PLANNING CONSULTATION RESPONSE

Application No	2025/1082
Proposal	Discharge of conditions 3 (Tree Protection), 4 (Landscaping), 5 (Materials) and 6 (Boundary Treatments) of application 2025/0490 - Erection of 1no detached dwelling (custom/self-build).
Address	Land adjacent to 102 Hawshaw Lane, Hoyland, Barnsley, S74 0HH.
Date of Consultation Reply	10/02/2026
Consultee	Edward Jowett (Tree Officer)

Proposed Landscaping Plan
scale: 1:100

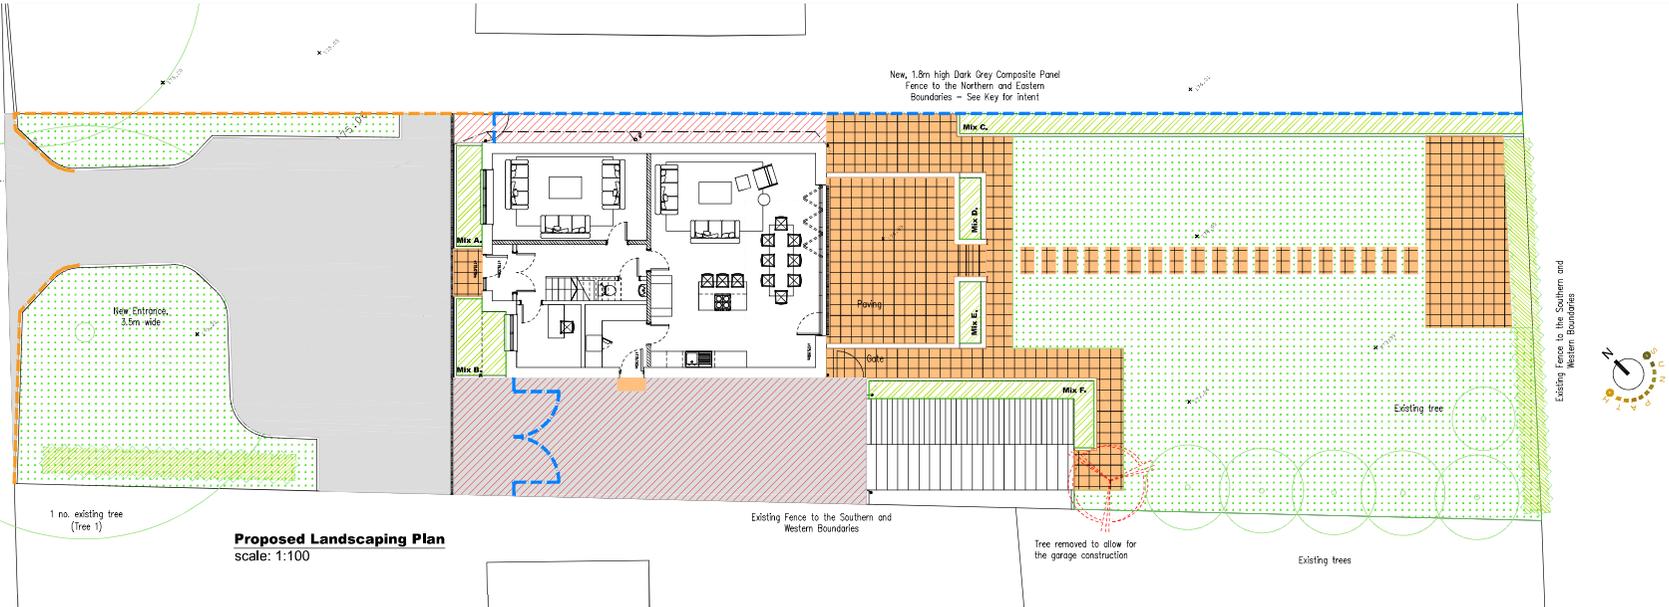
The soft landscaping element of the landscaping scheme required under condition 5 and the new planting proposed as part of it is acceptable from an arboricultural perspective. The amendments agreed for the boundary treatment in close proximity to the trees is acceptable but will need to be reflected on the landscaping scheme in order for this condition to be discharged.

Providing the landscaping information is updated to reflect the fencing agreed there is no objection to discharging conditions 3 and 5.
